Summary of Submissions and Proponents Response (20/01/11)

June 22nd 0900

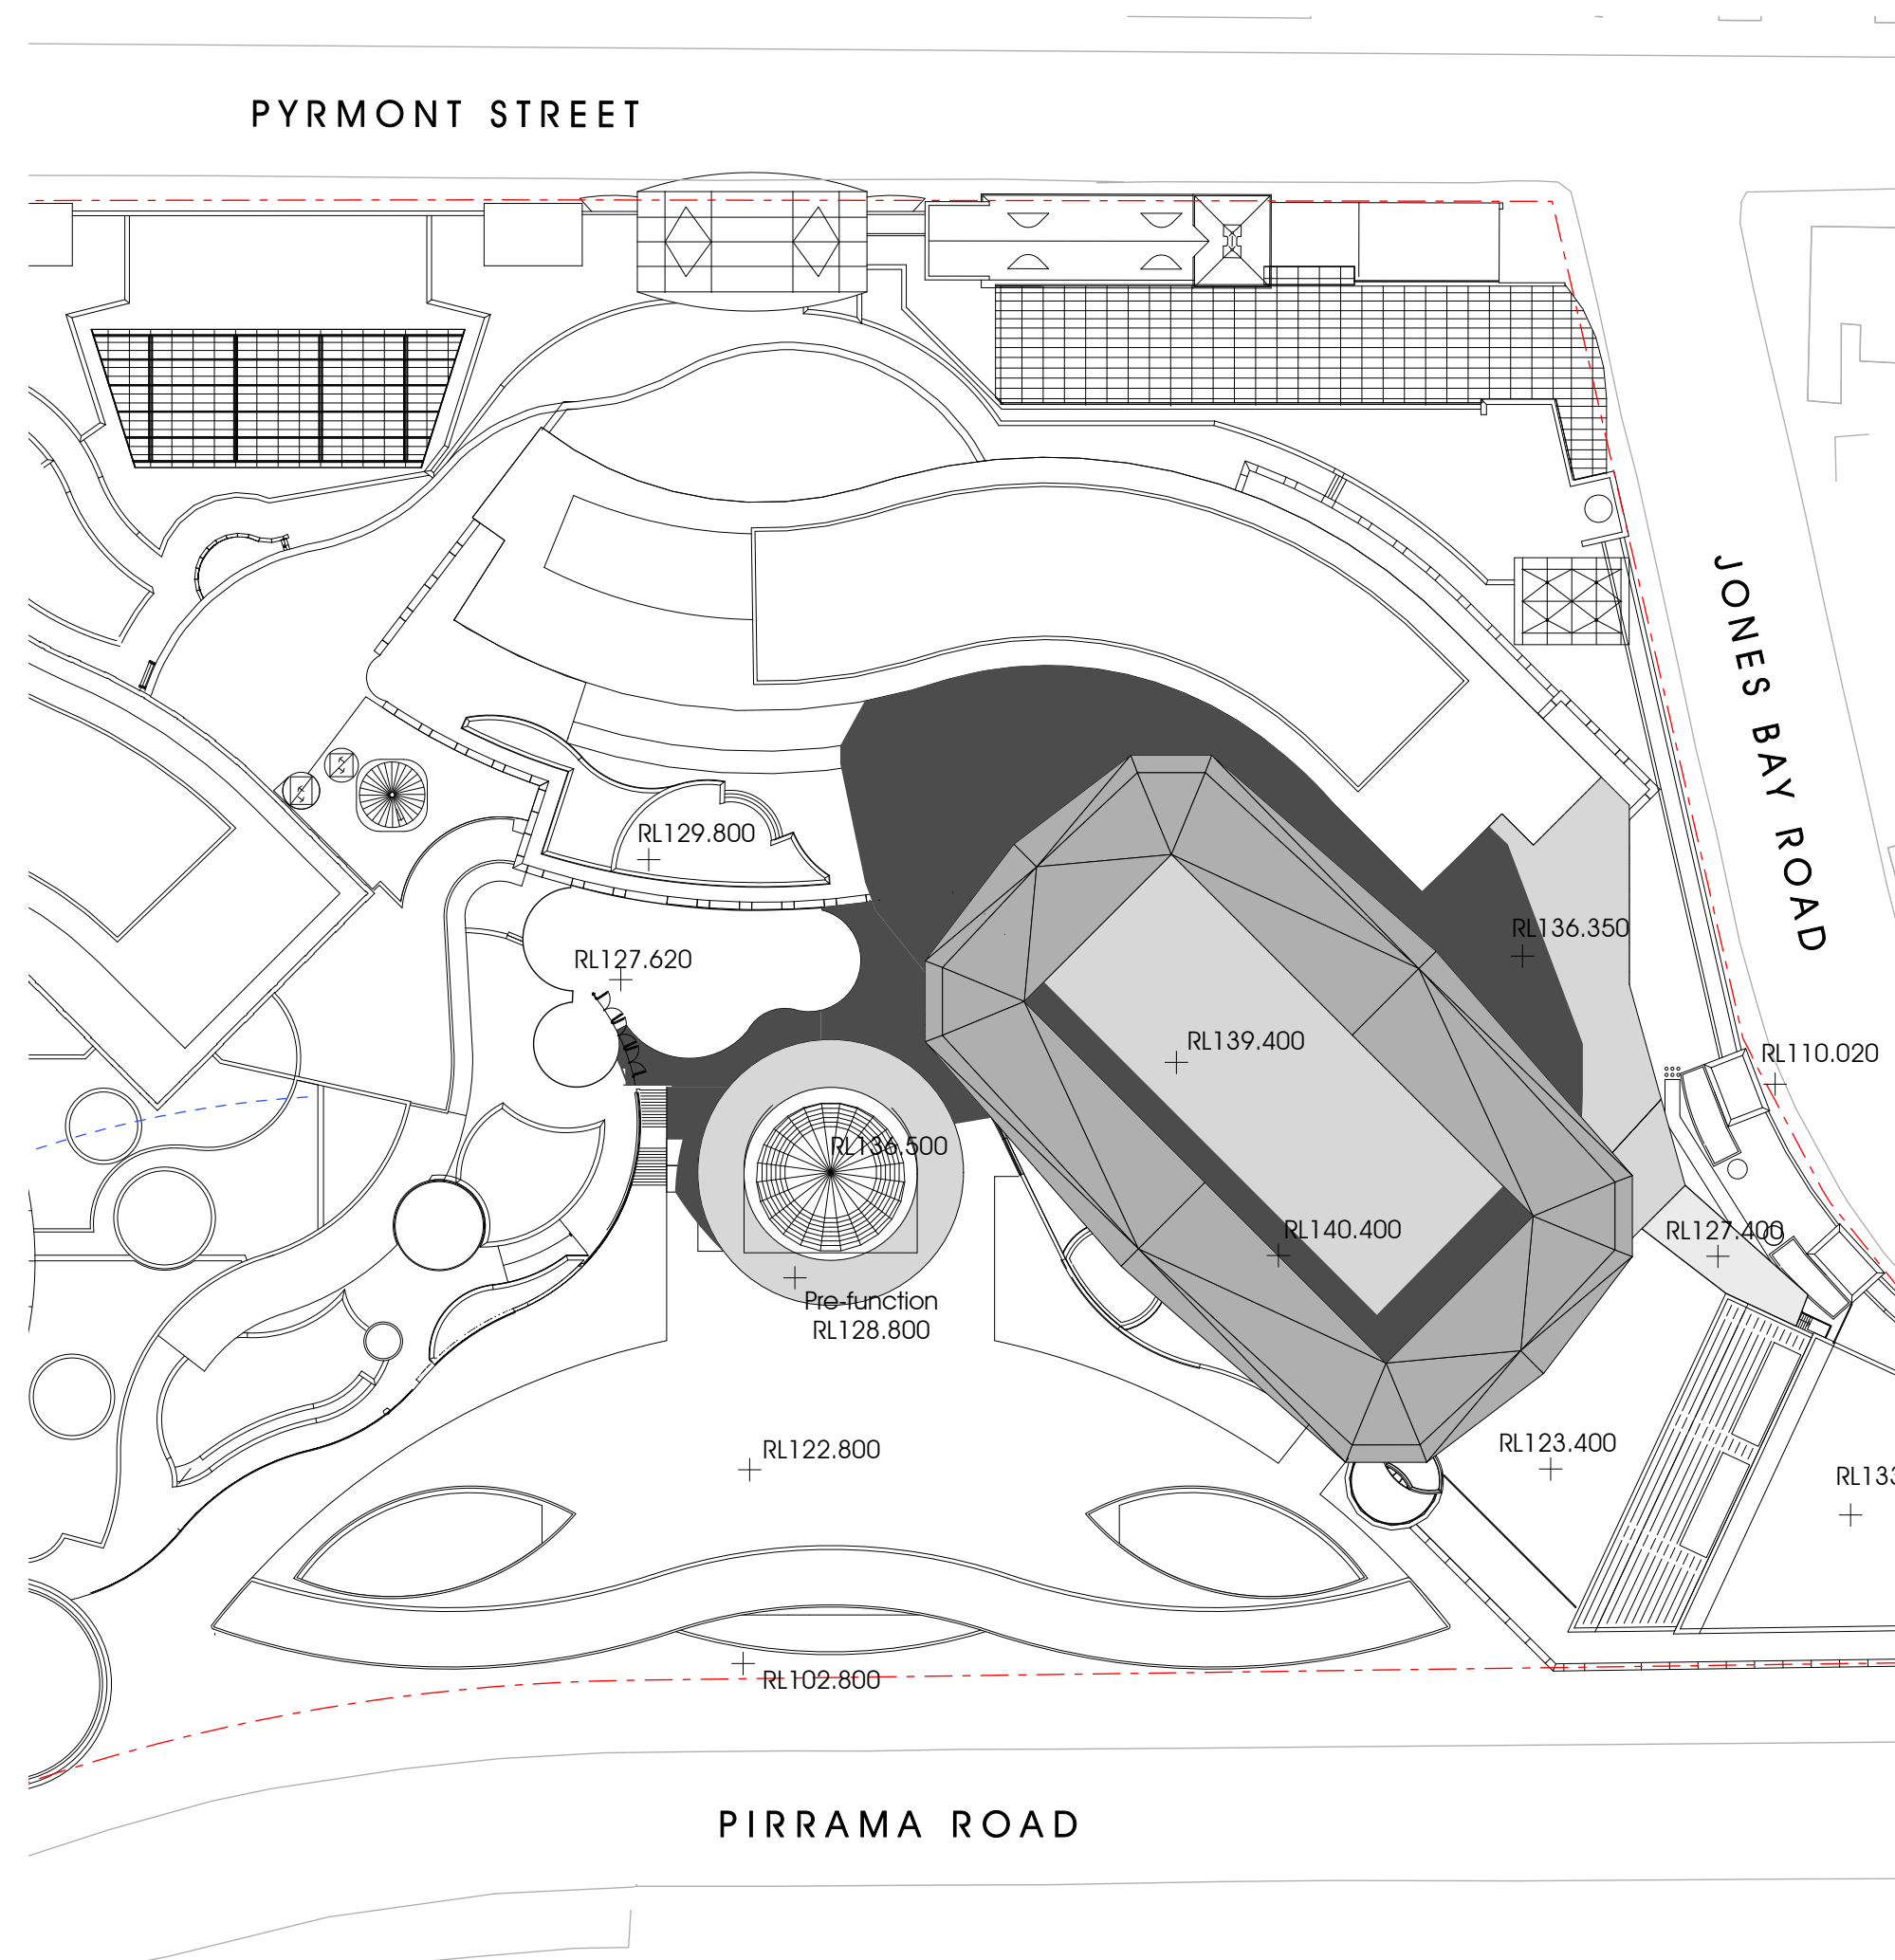
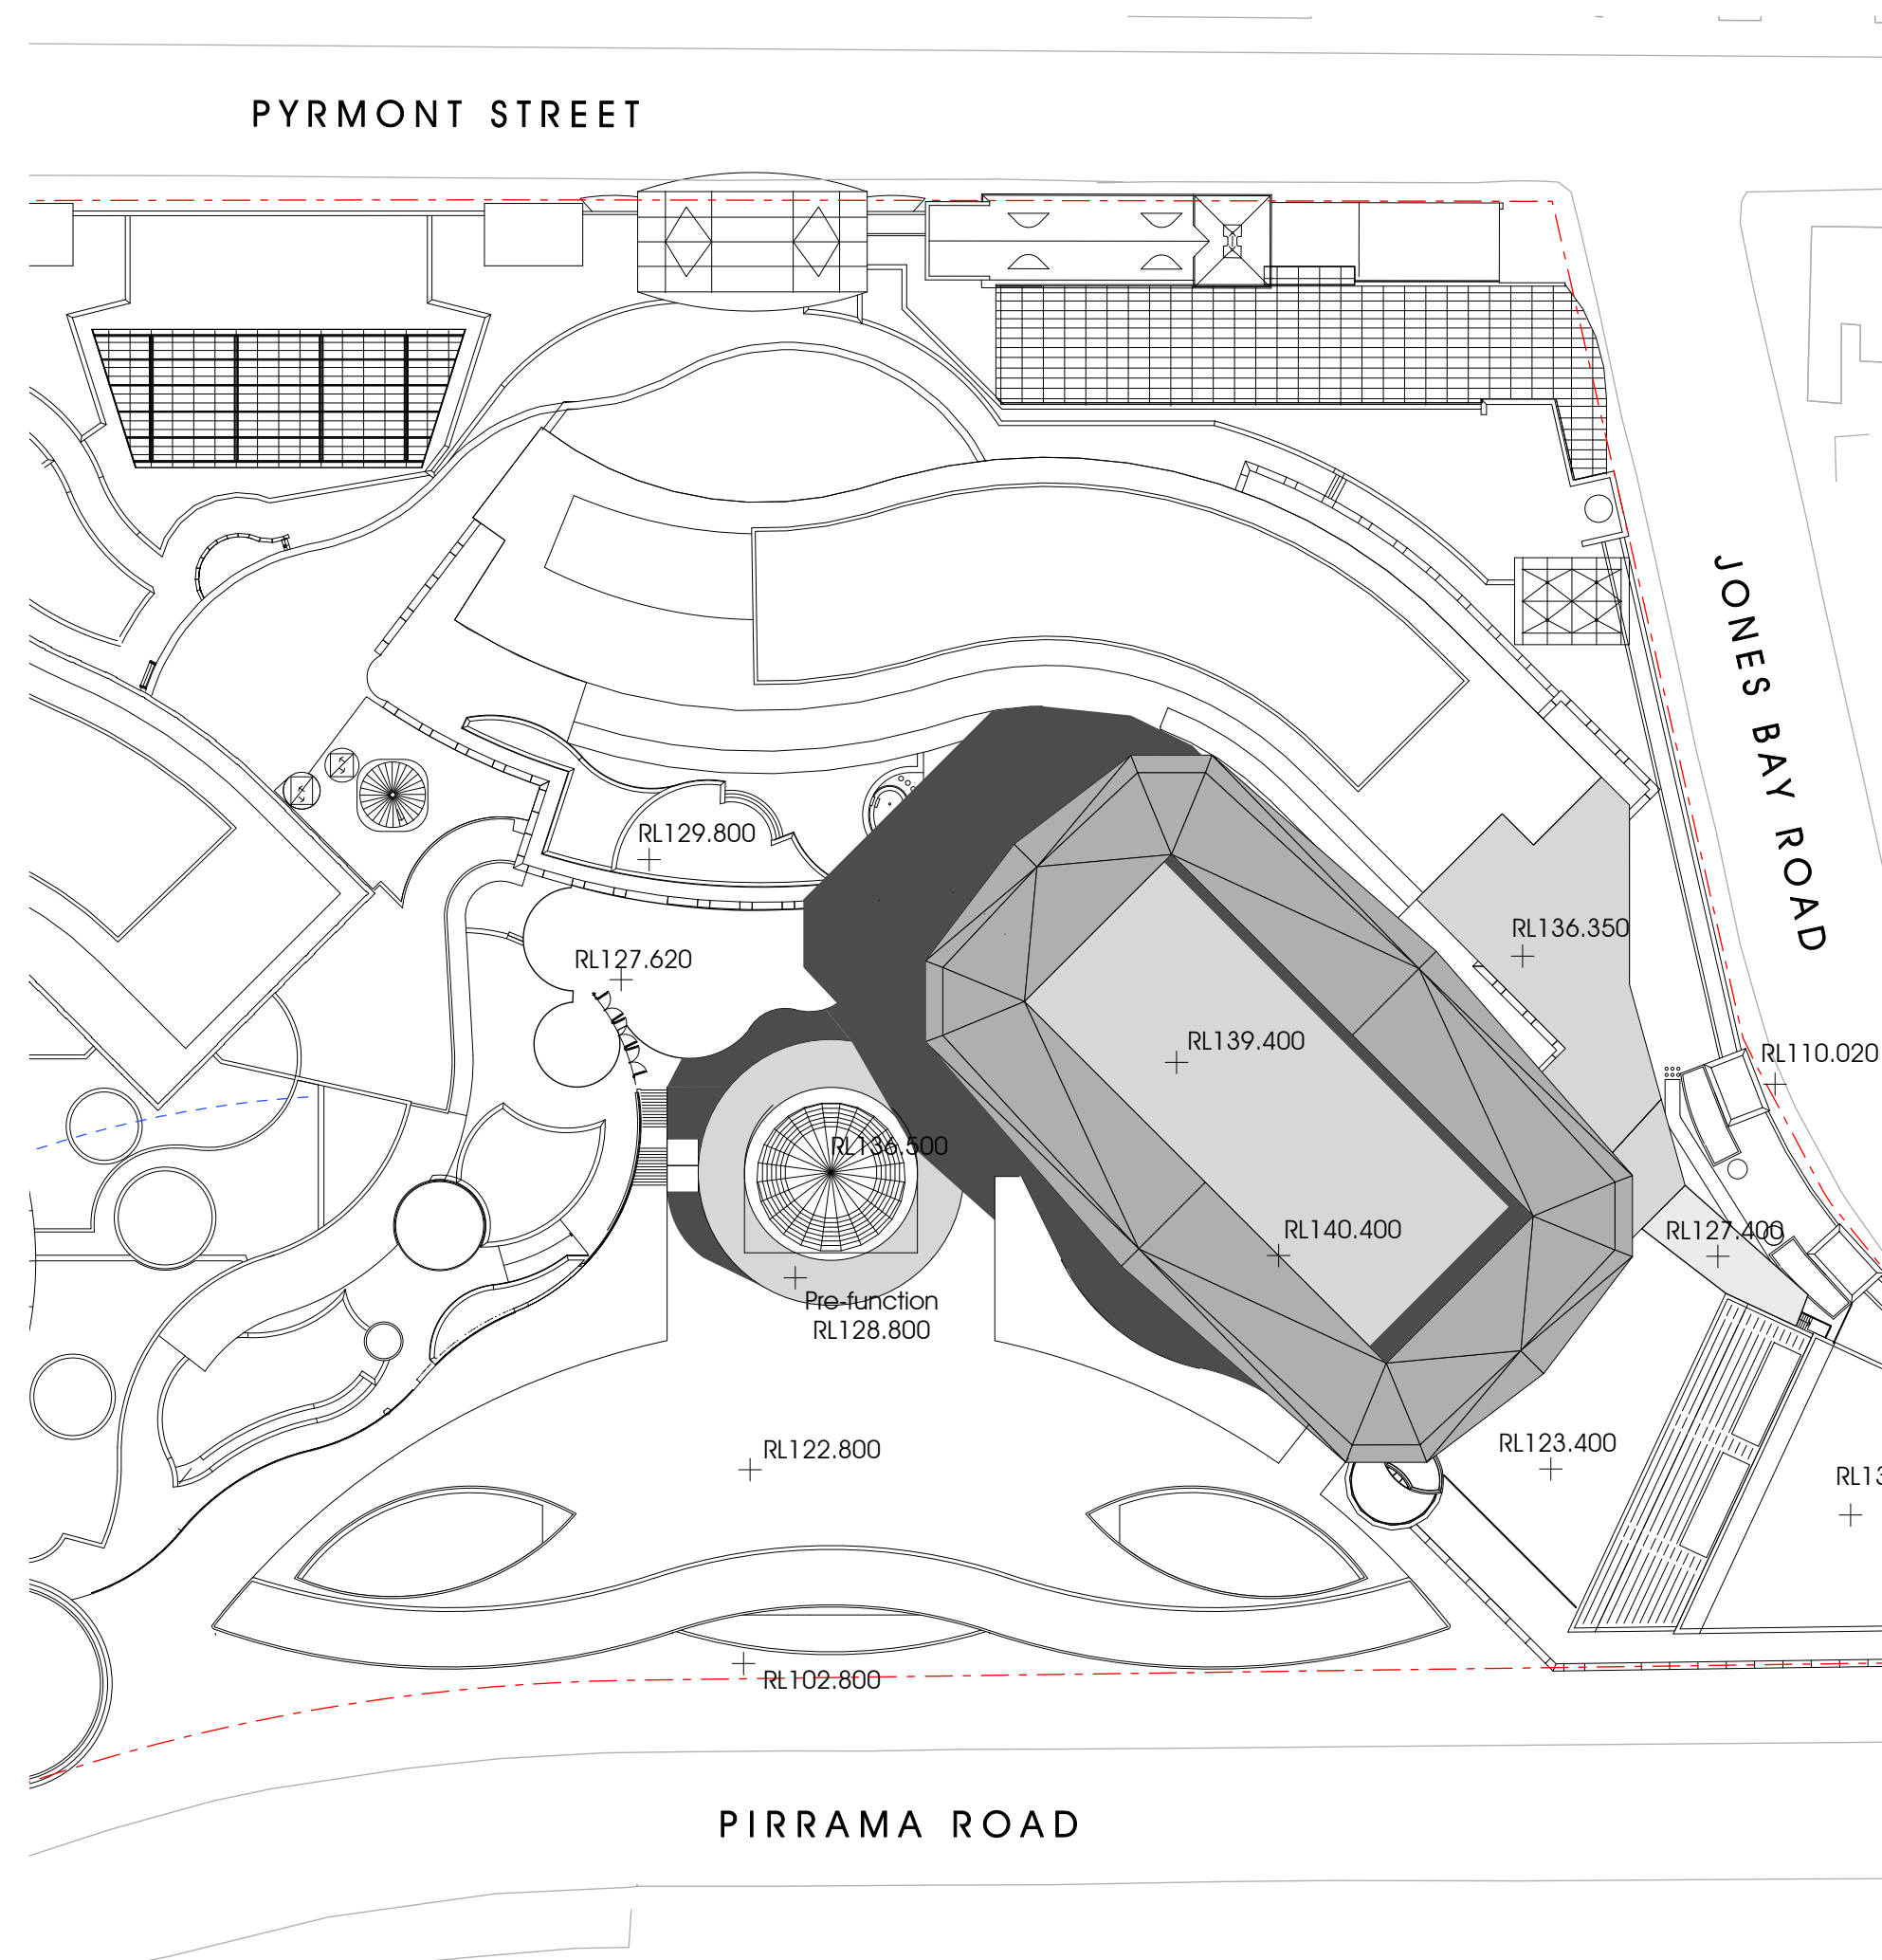
<p>Robert Wirth, Warwick Saunders, Zena Vaasssen, Stafford Van Putten 14 & 16 Pymont St, Pymont 11/12/10</p>	<p>Proposed development will adversely affect the quality of life for residents of 14, 16 and 18 Pymont Street (as well as the Watermark Building). The increased height will result in loss of already limited sunlight access to the rear of these properties. The issue of loss of light and its impact on the community has not been addressed by the Casino developers.</p>	<p>These properties are located towards the north-west of the MUEF. Submitted shadow diagrams illustrate that the MUEF will not cause overshadowing to these terraces.</p>
